DELEGATED DETAILS DECISION

Report of the Head of Planning, Building Control, Sport & Green Spaces

Address RAF WEST RUSLIP HIGH ROAD ICKENHAM

LBH Ref Nos: **38402/APP/2015/851**

BLOCK D - ELEVATION 3
SW ELEVATION

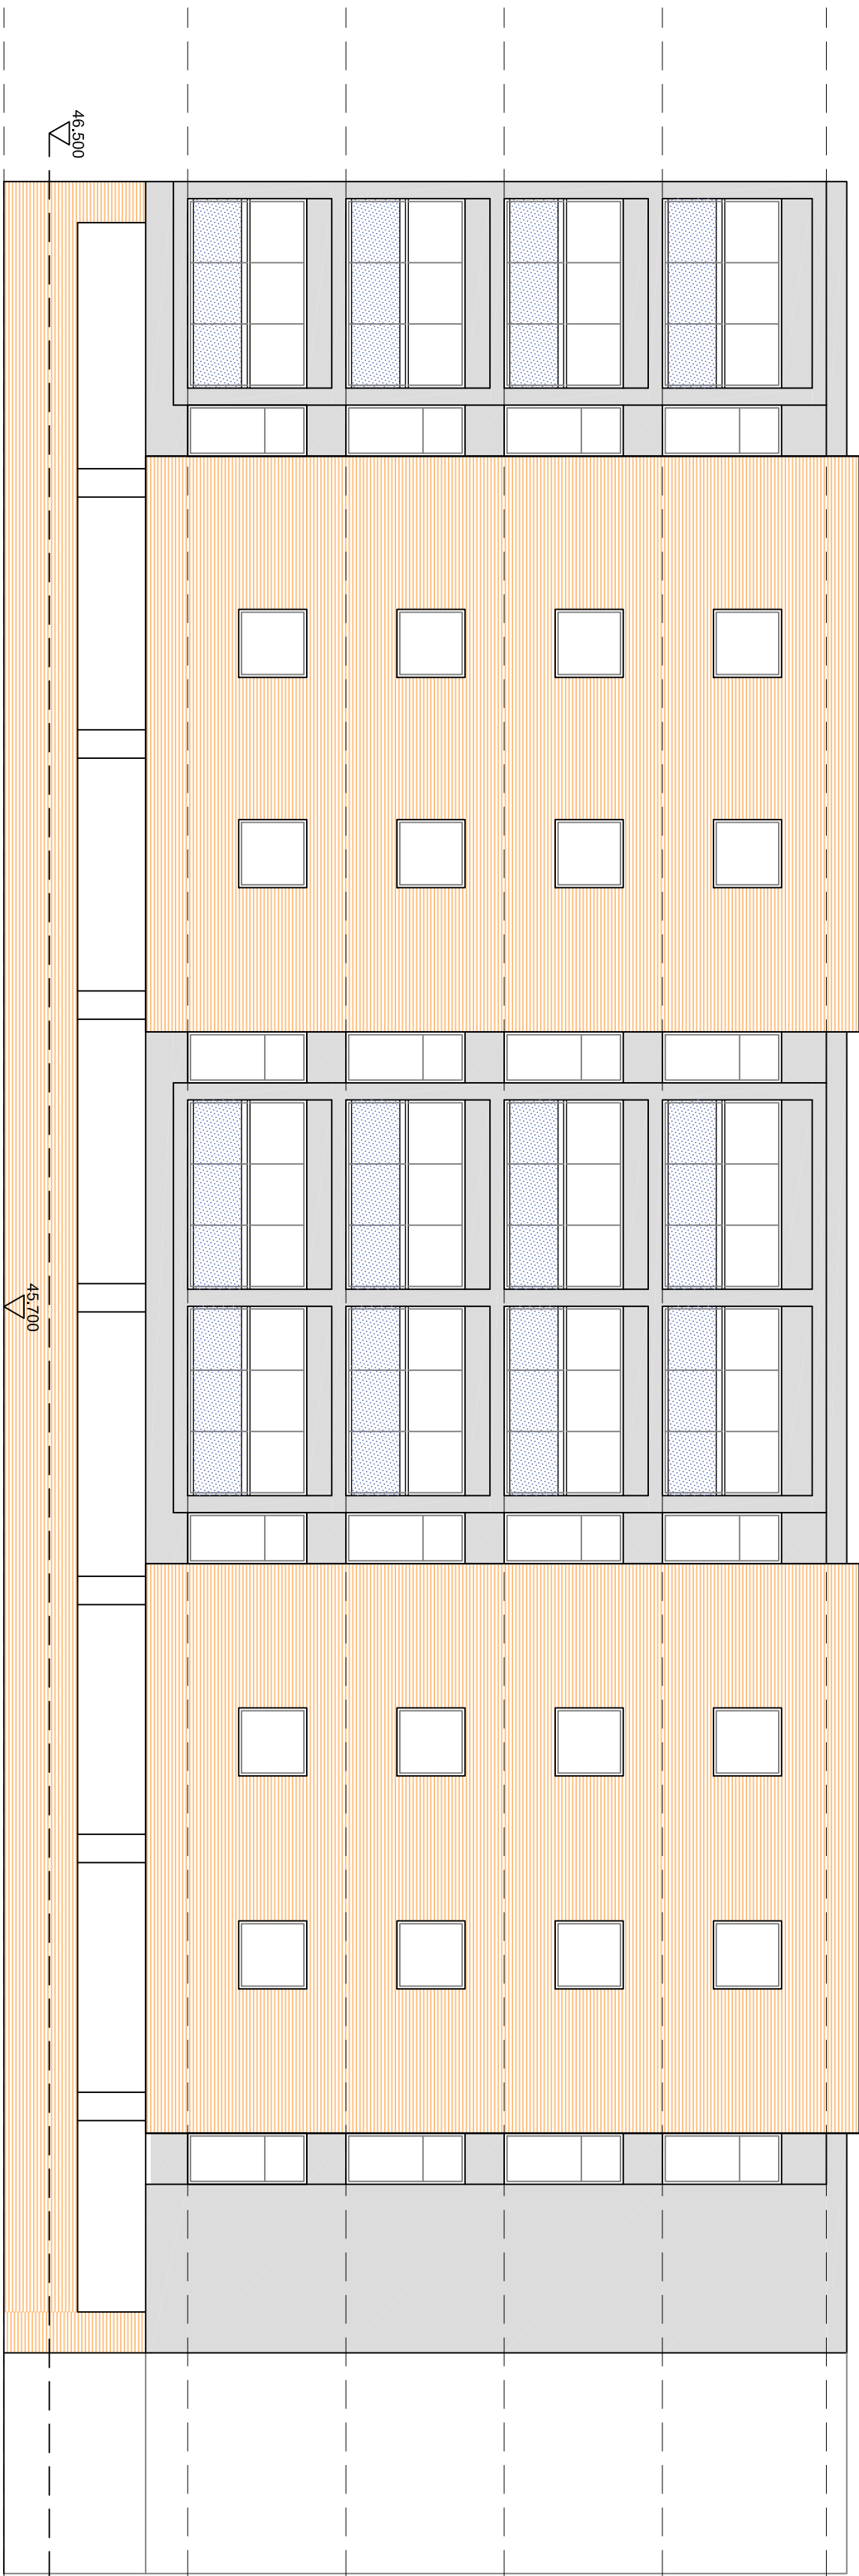
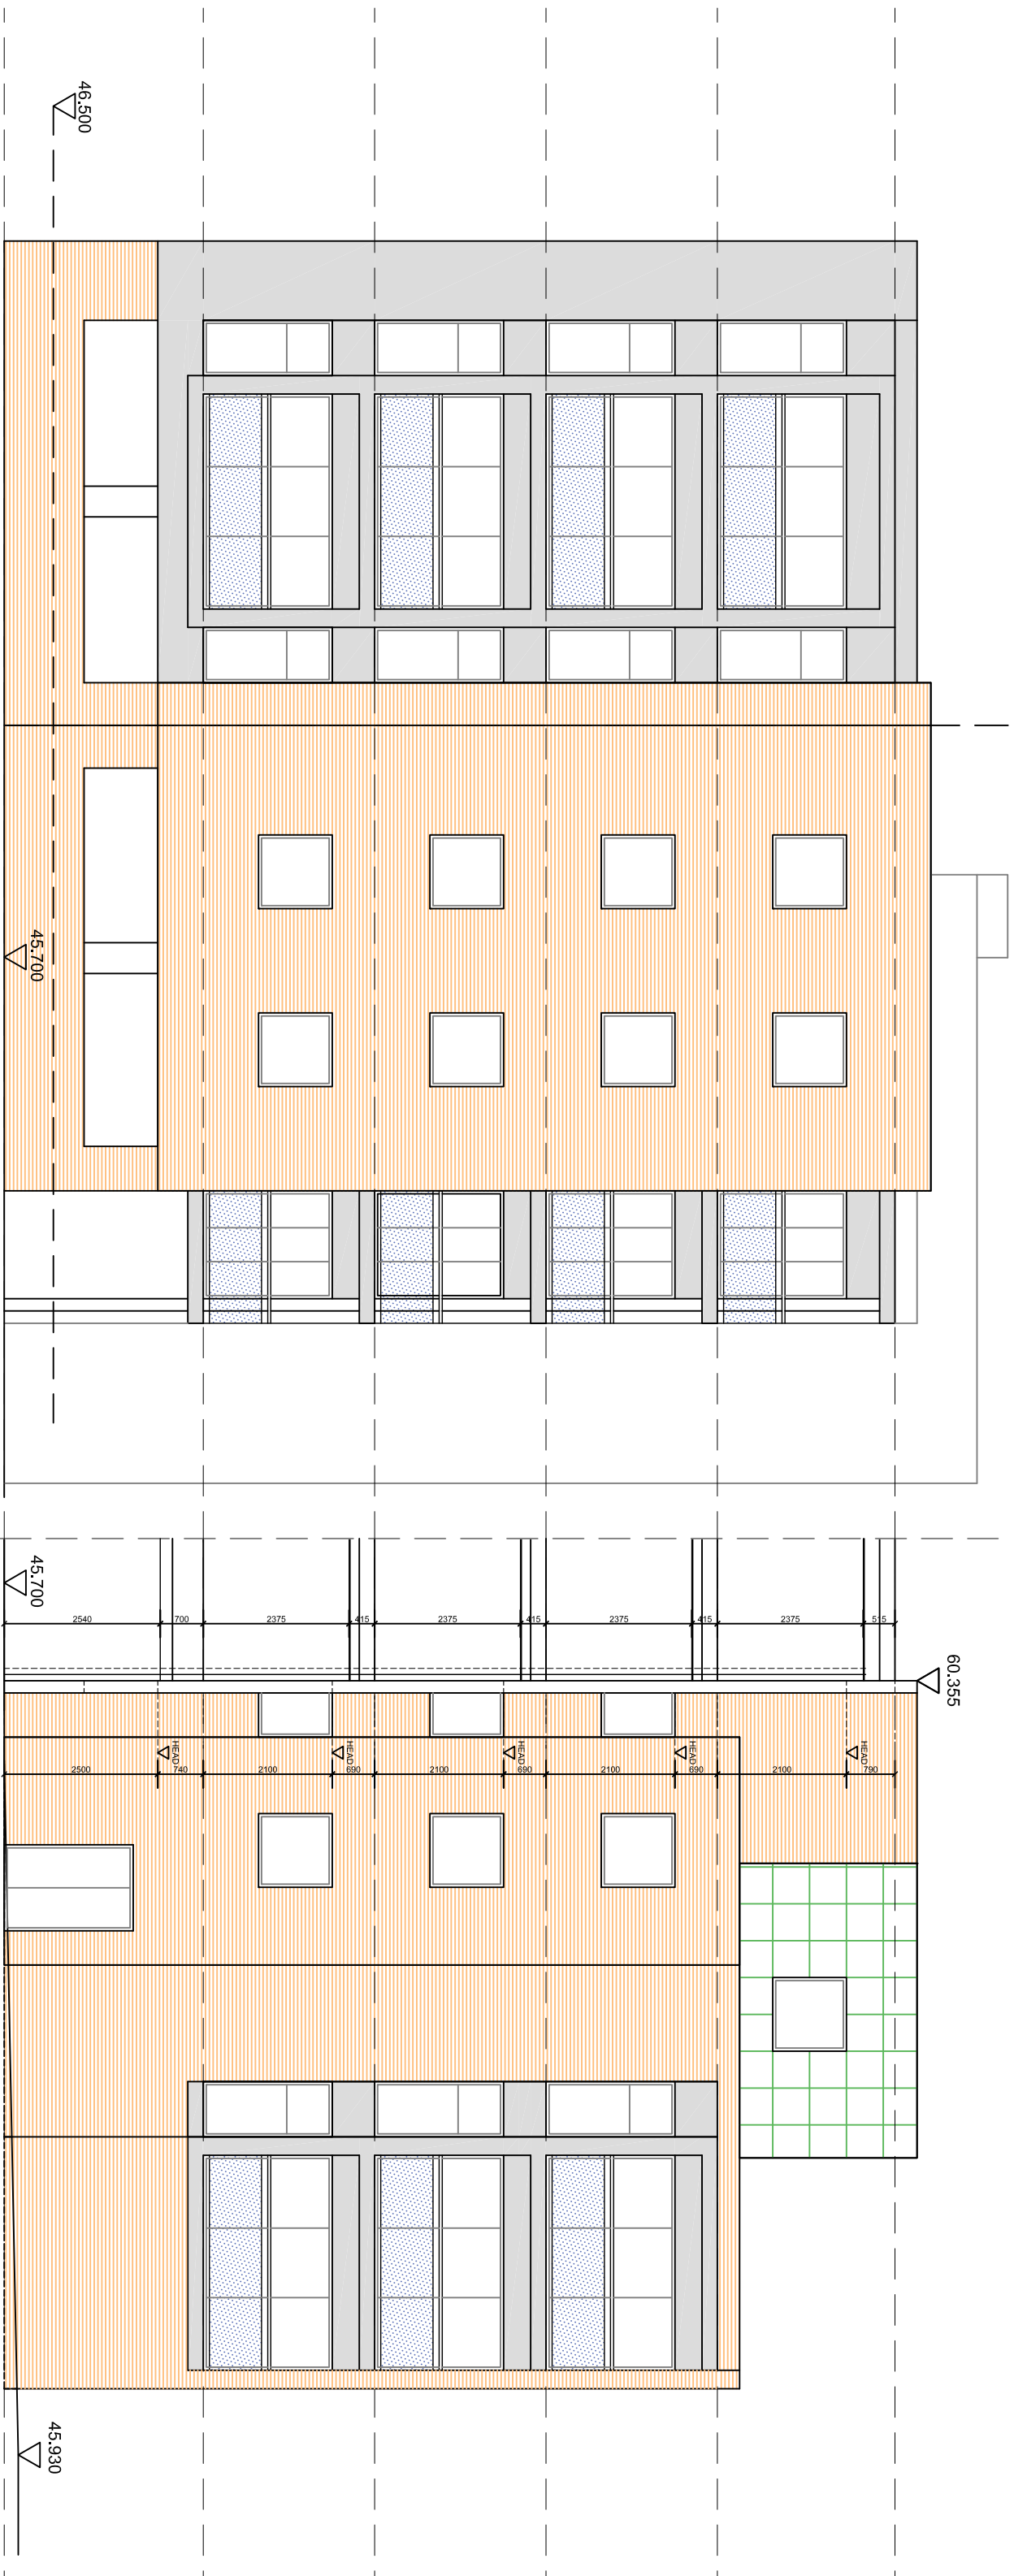
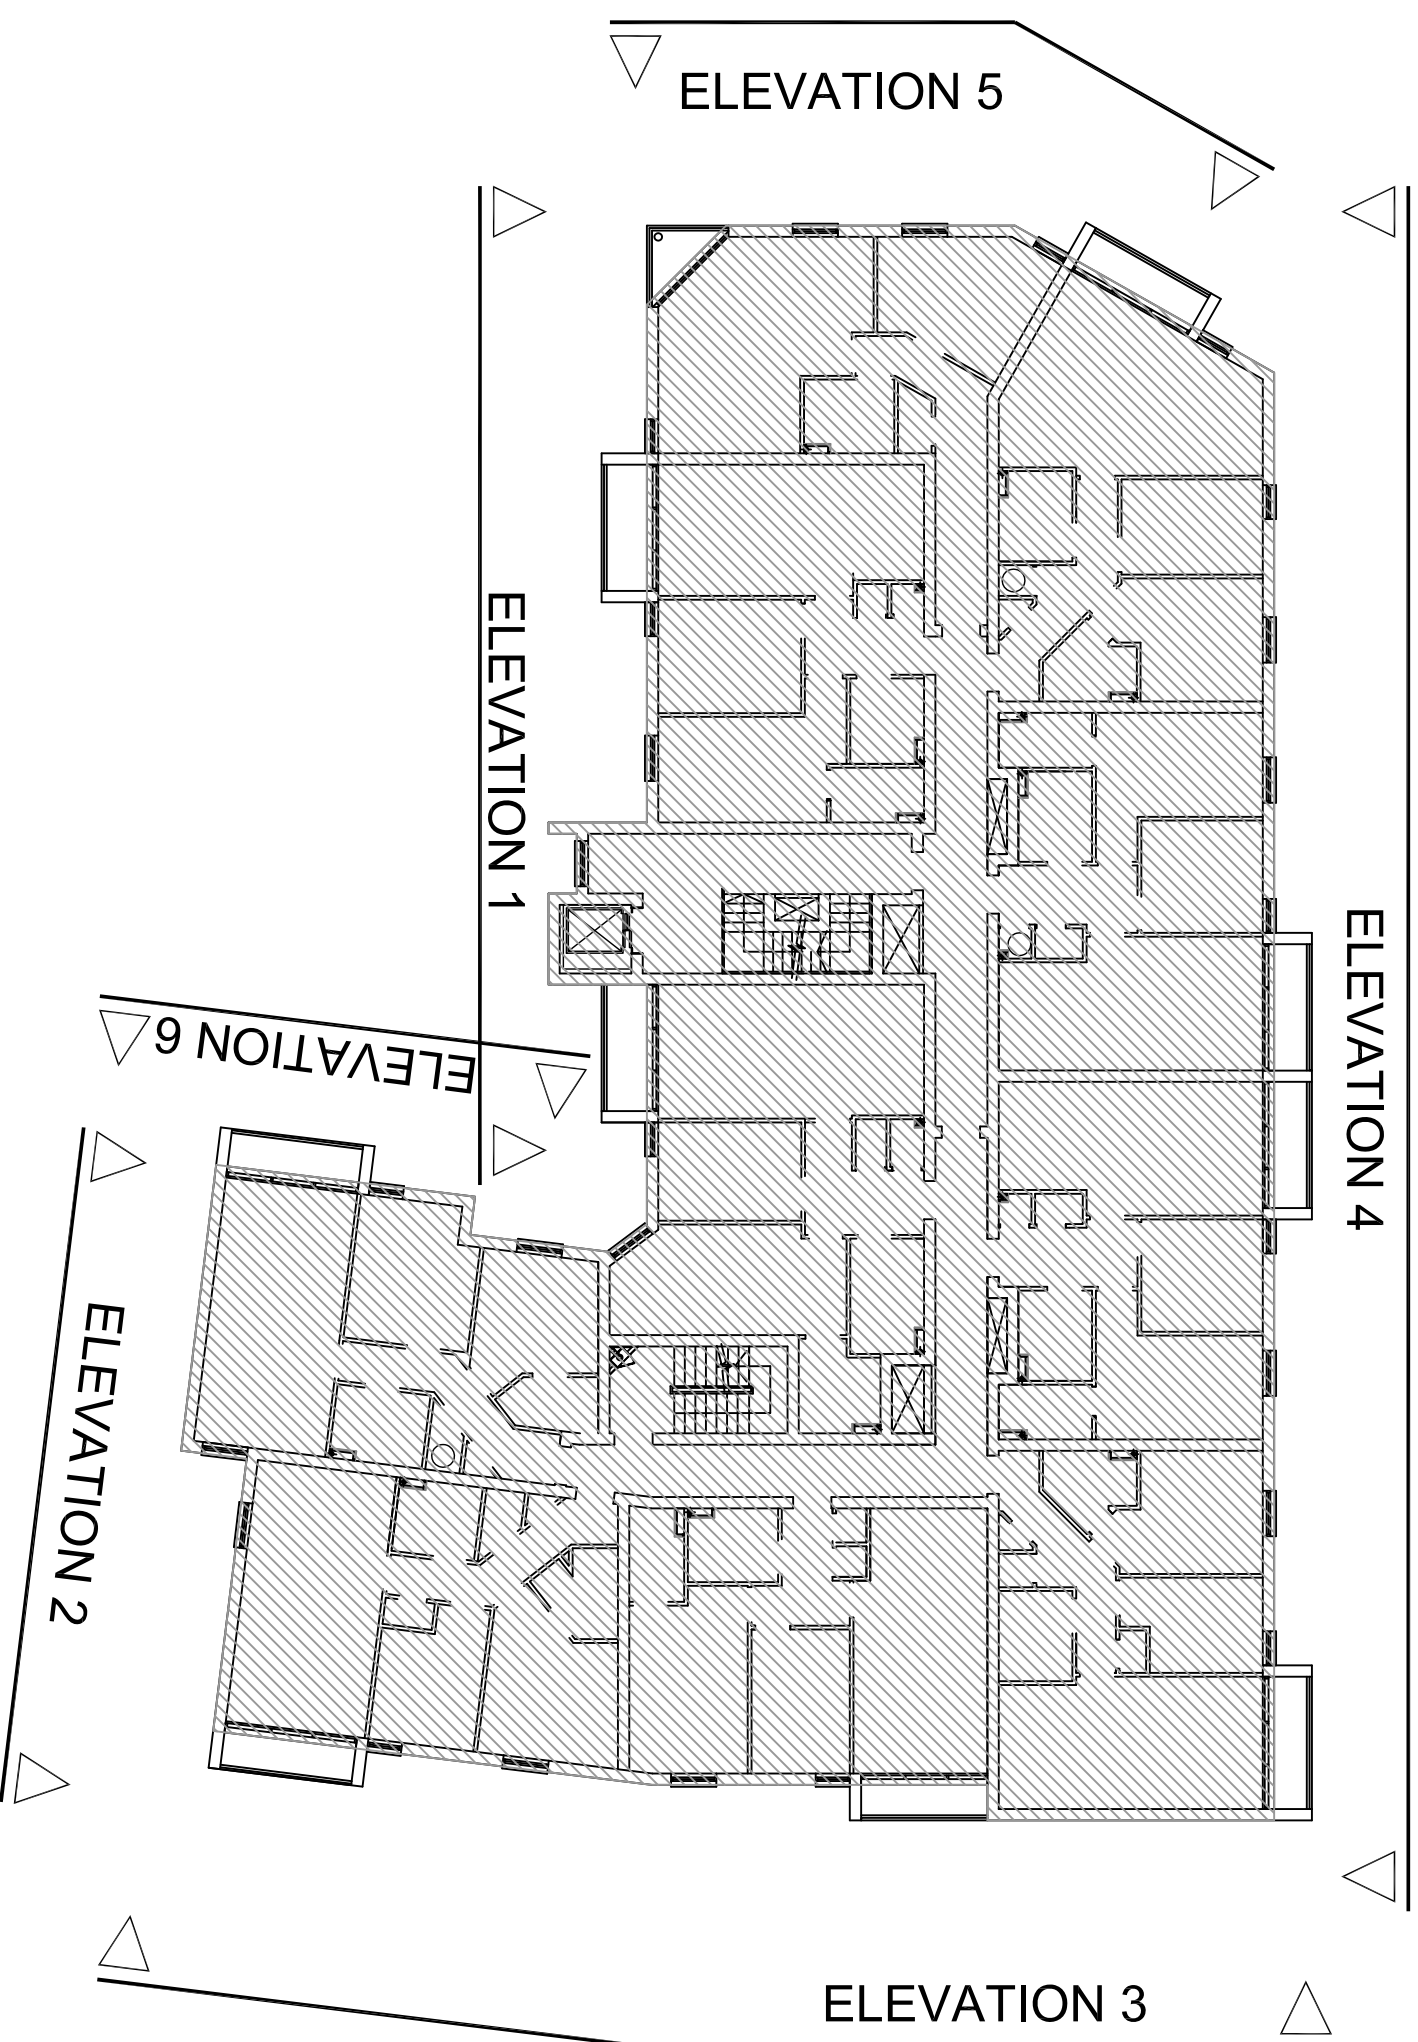
There are, however, concerns re the materials for the two blocks of flats. Whilst these appear to be the same as approved for the existing block adjacent to the

station, this structure as built does now appear to be overly prominent in the street scheme, not only because of its height and bulk but also because of its light coloured rather bland looking materials. If possible, the use of these for this phase should be reconsidered, and a darker more textured brick and a more recessive cladding colour for the upper floor used.

I still think the proposed yellow bricks are not the best, the bricks used on the other side of the site look better, with more texture and a subtle variety in colour. But I don't know how far we can object to the bricks as proposed if we have agreed them for use on this part of the site previously.

The revised proposed brick for use on the flats is acceptable and the other changes to the materials for the houses are also acceptable.

Following the Urban Design/Conservation Officer's initial comments, the bricks for the flatted blocks have been amended and are now slightly more textured. The tiles have been approved previously on the adjoining phases. The agent has also confirmed that the weatherboarding on the projecting bays which are only present on 6 houses would be Eternit Cedral, colour - white. The Urban Design/Conservation Officer is satisfied with the proposed materials.
